STATE OF NORTH CAROLINA DEPARTMENT OF TRANSPORTATION

Addendum No. 1

RE: Contract ID: C202720
WBS# 1CR.10701.3, etc.
Pasquotank County
NC-344 From Ehringhaus Street To End of Five Lanes

March 15, 2011 Letting

**TYPICAL SECTION #1**

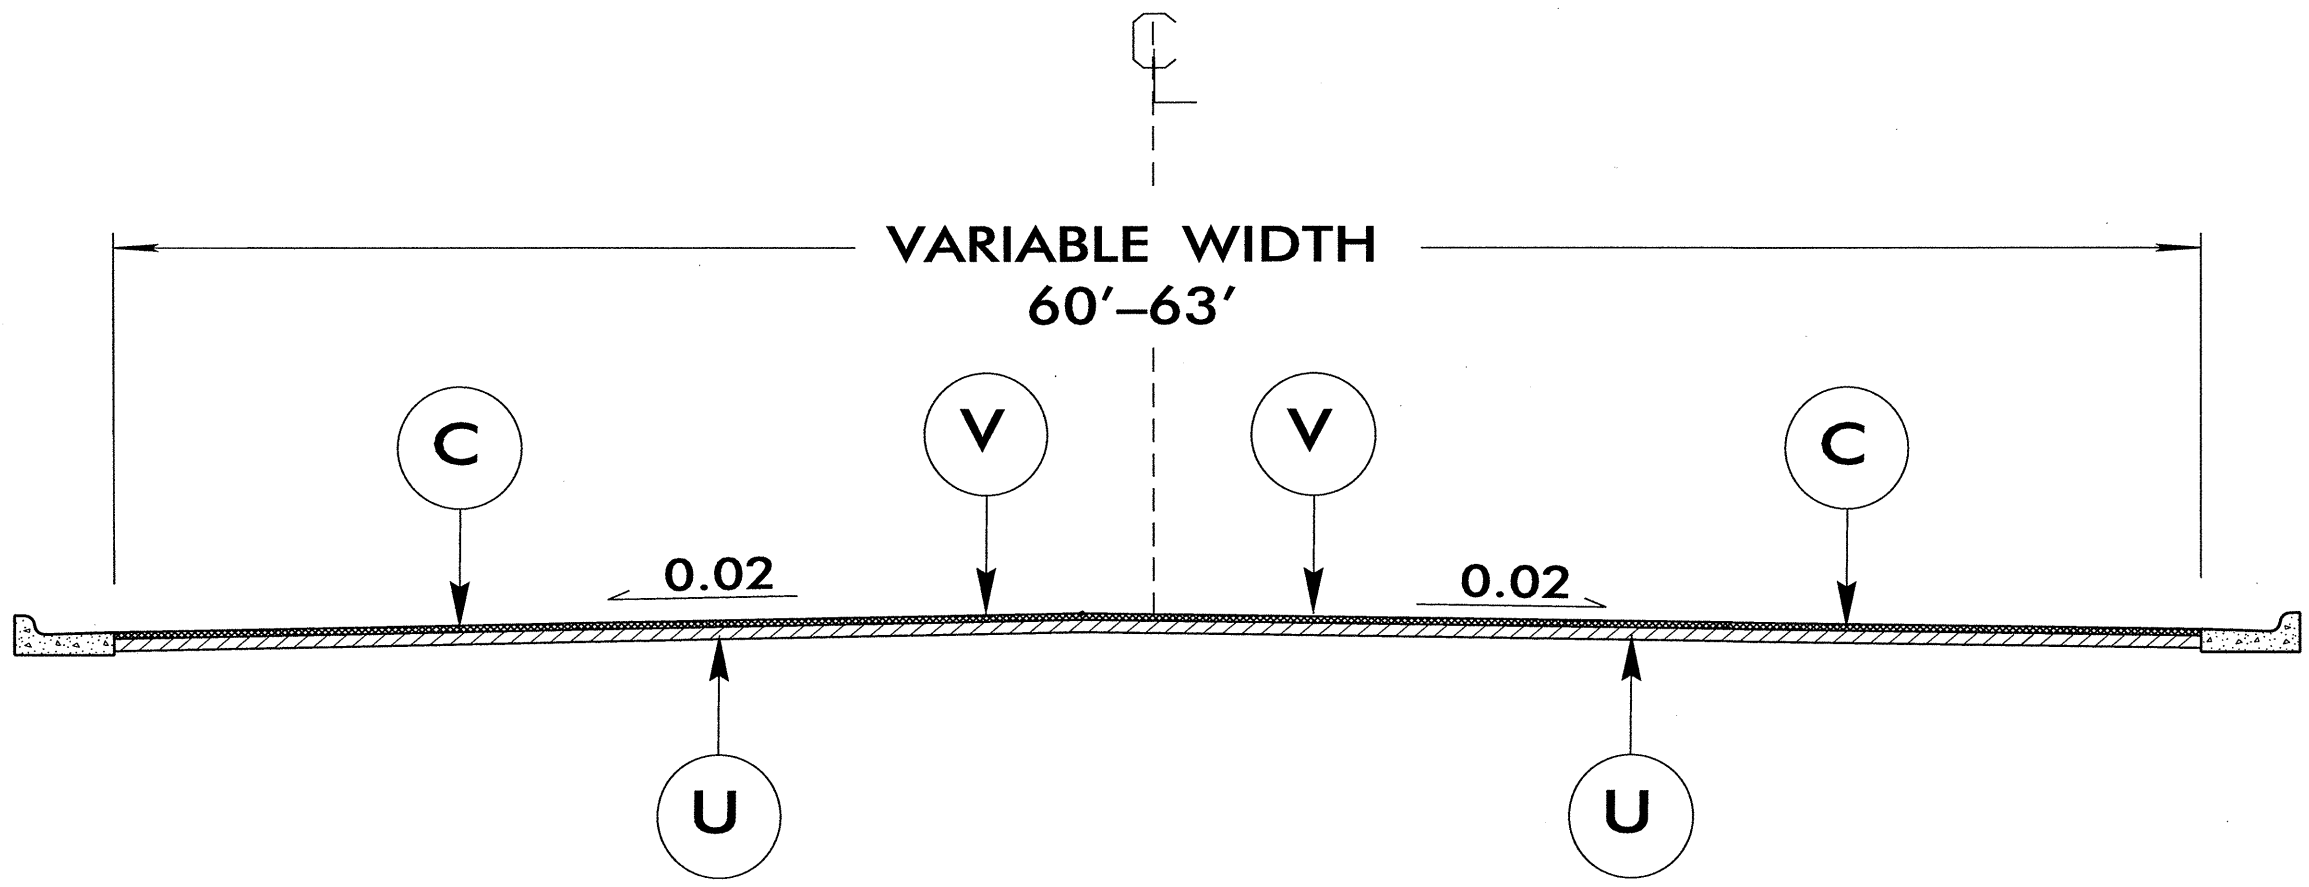
On Sheet No. 2 a note has been added concerning placement of inductive loops. Please void Sheet No. 2 in your sketch maps and staple the revised Sheet No. 2 thereto.
